RE: Casitas Del Camino at 120 60th ST NW – Erosion & Sediment Control Plan (SWQ-2025-00061)

E2RC thanks you for your correspondence and comments regarding the Casitas Del Camino project. This letter and attachments are provided in response to your letter.

EXISTING / DEMO SITE PLAN

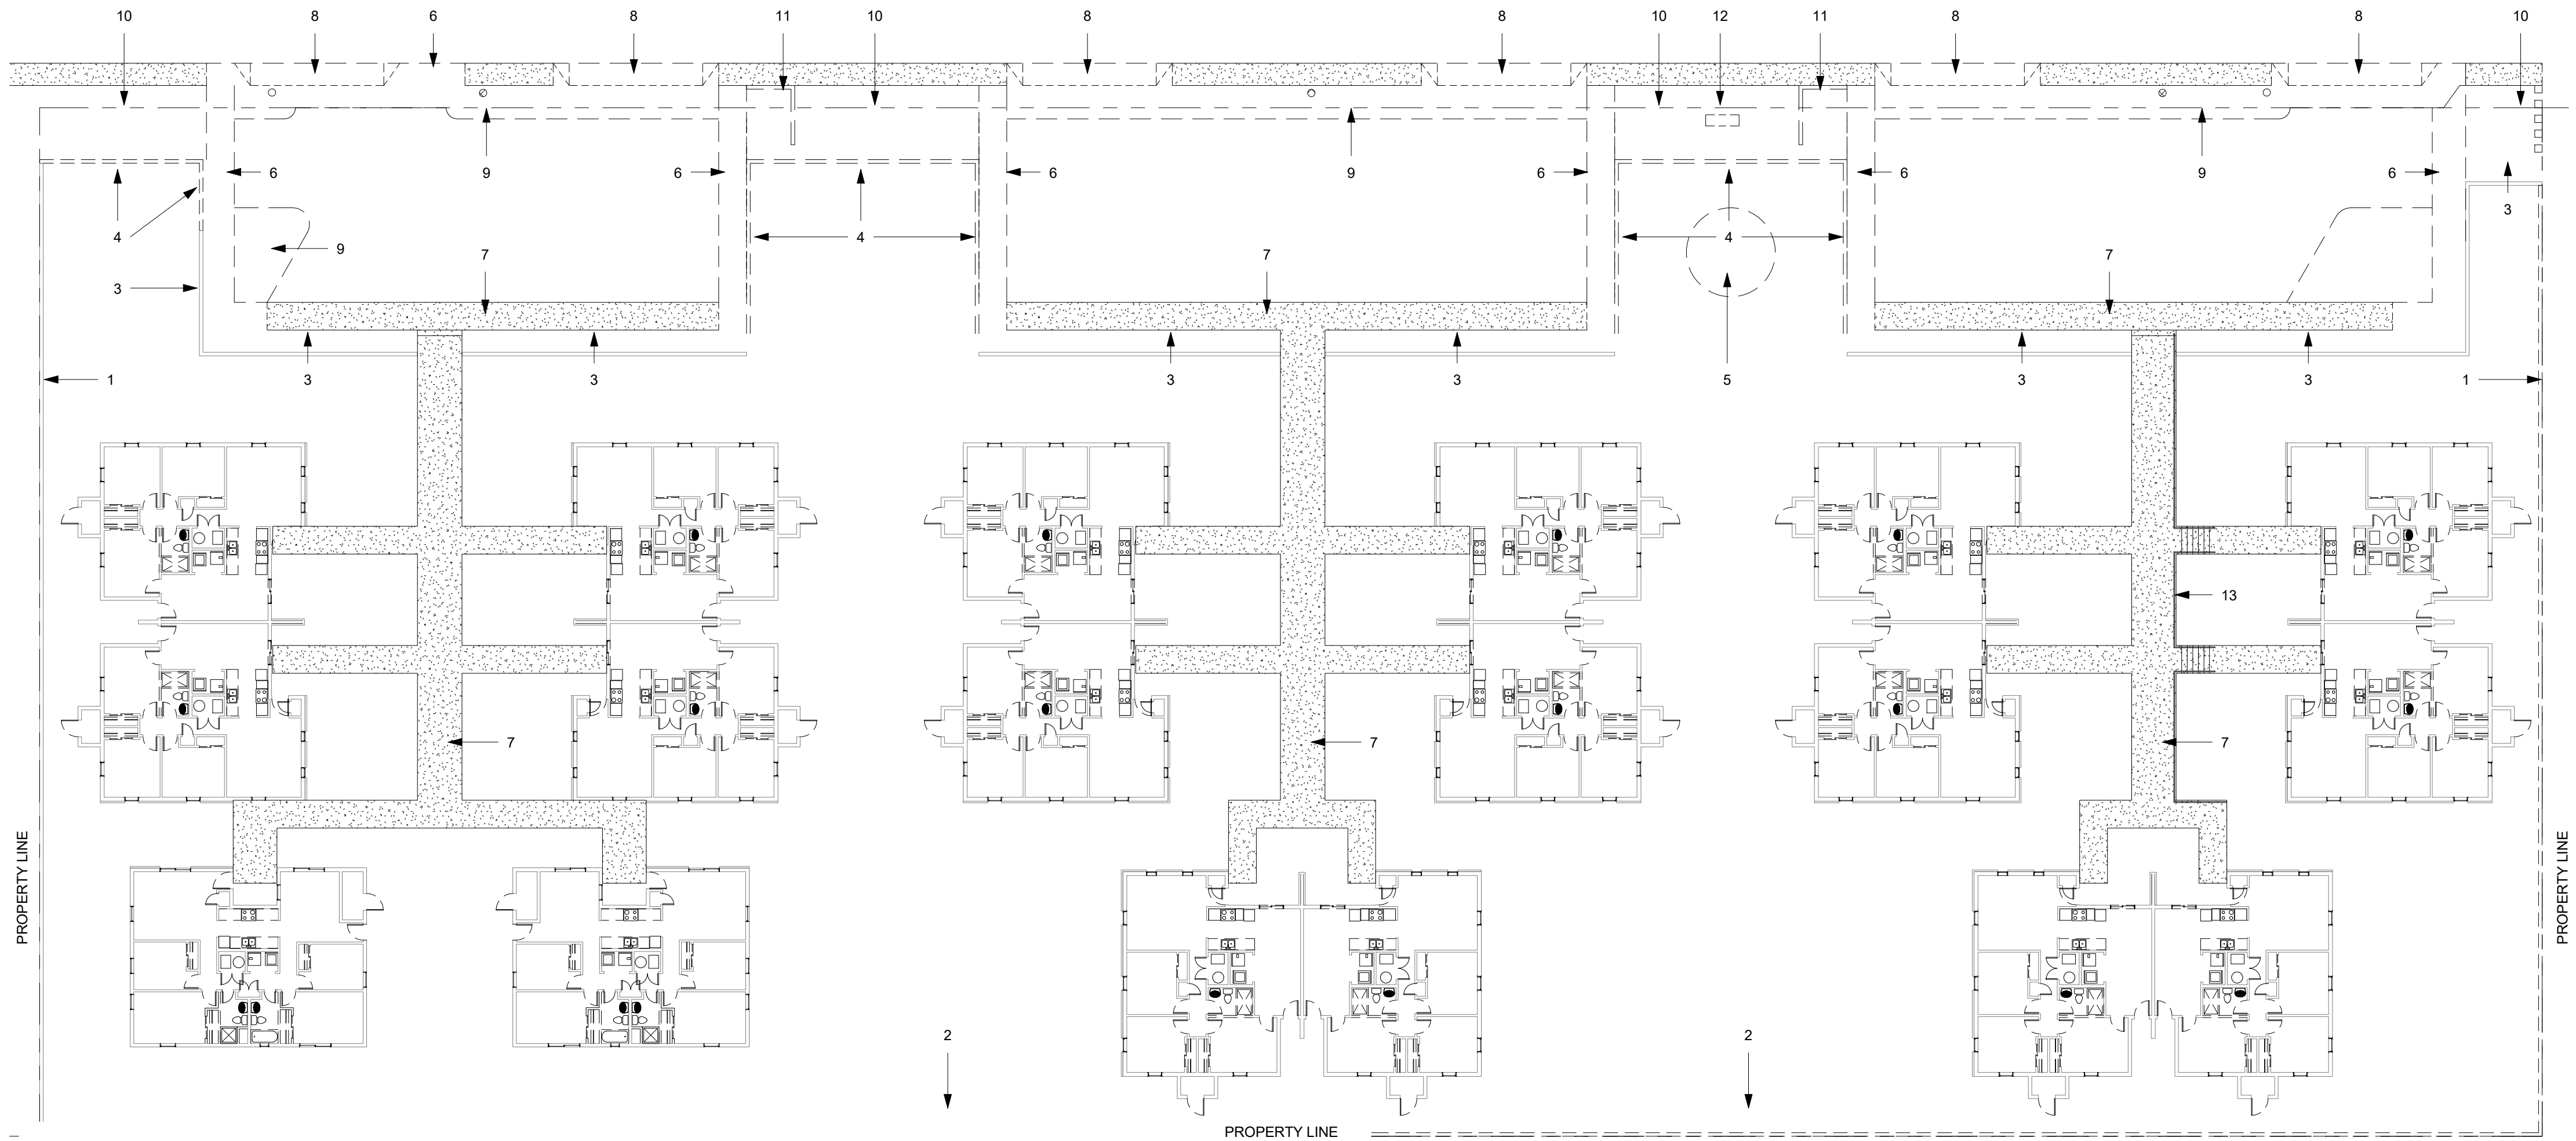
6. Add a separate sheet for demolition. This sheet is enumerated as 'AS1.3' and located as the ninth sheet in the drawing set. Notations for this work are included on Sheet 3.
